Lime Down

Solar Park

Statement of Common Ground with Natural England (Tracked)

Document Reference: EXAM/8.4

Title:
Figure 4-4: Main Infrastructure Layout Changes between PEIR and DCO Application

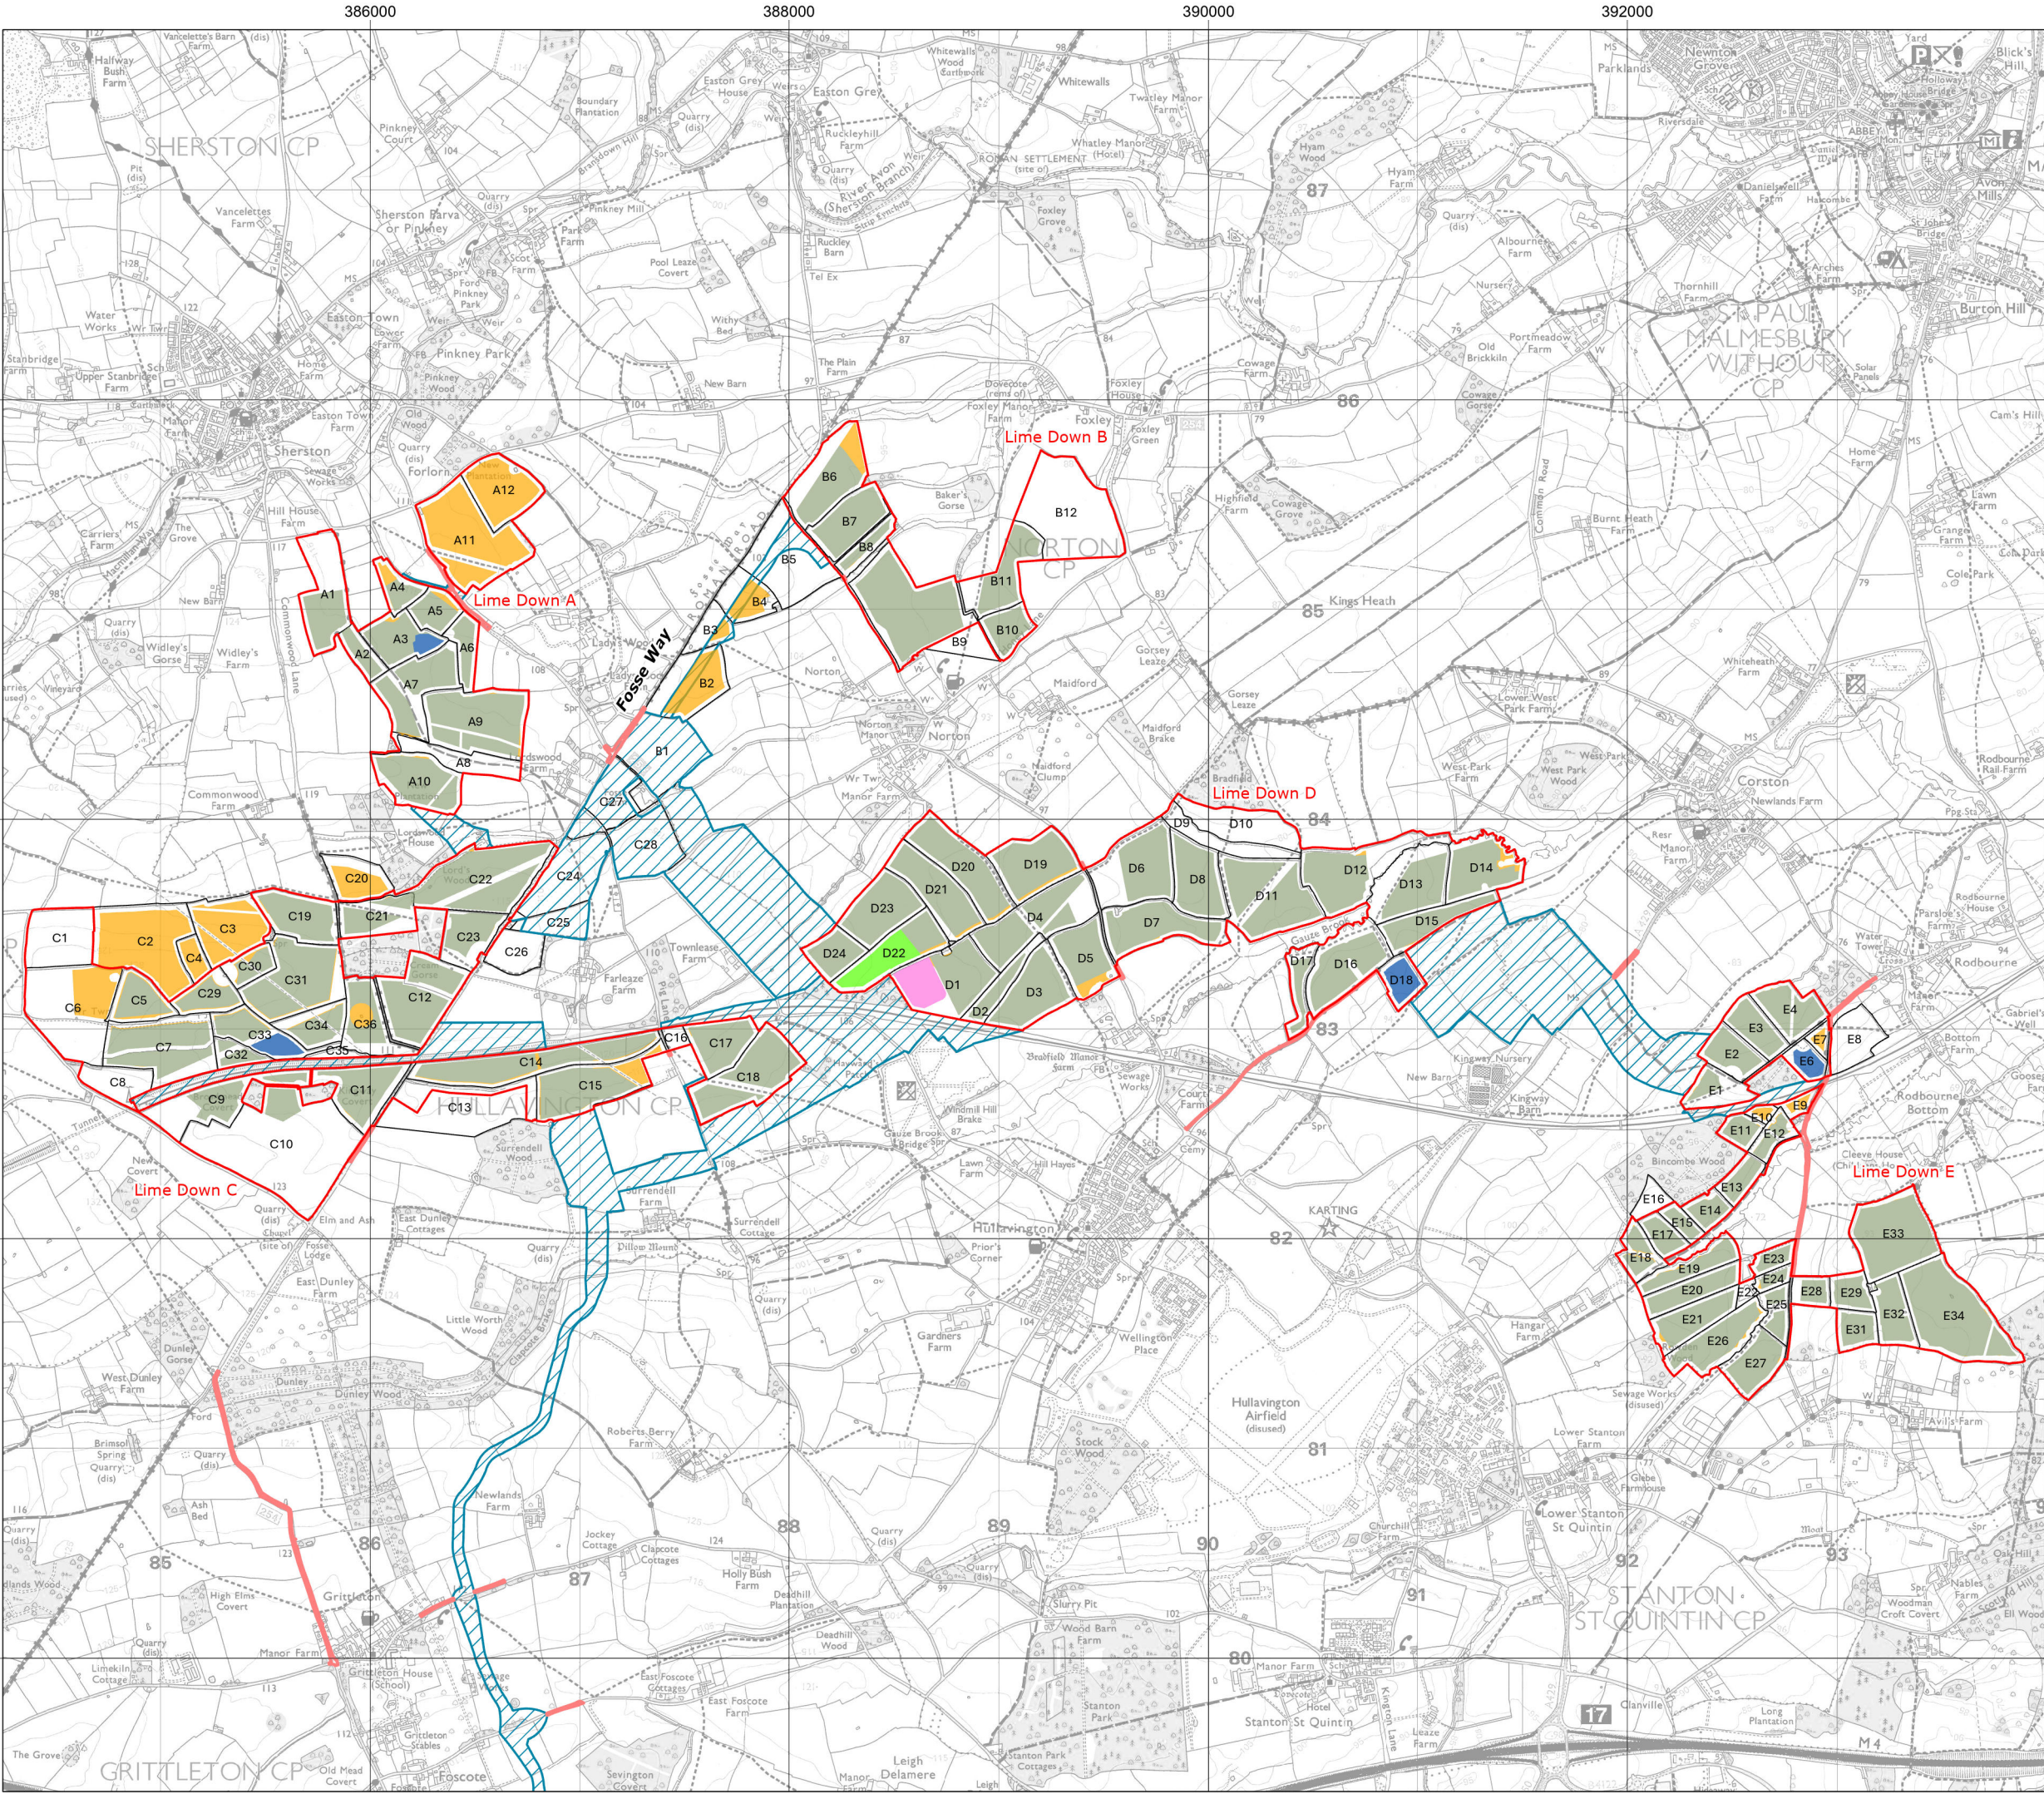
Reference	Sub-topic	NE Position	Applicants Position	Status
3.1.1	Extent of panels within Lime Down C	Recommended that the extent of panels within Lime Down C is reviewed to avoid adverse landscape and visual effects on the CNL. Where panel areas are reduced, this should be used to provide landscape and ecological enhancements, particularly for lesser horseshoe bats.	As shown on the Works Plan, panels will not be located in the parts of fields directly adjacent to the National Landscape boundary within fields C1, C6, C8, and C10 retained clear of panels. Photomontages from 13 viewpoints demonstrates that this limits the landscape and visual impact of the proposed development.	Under Discussion
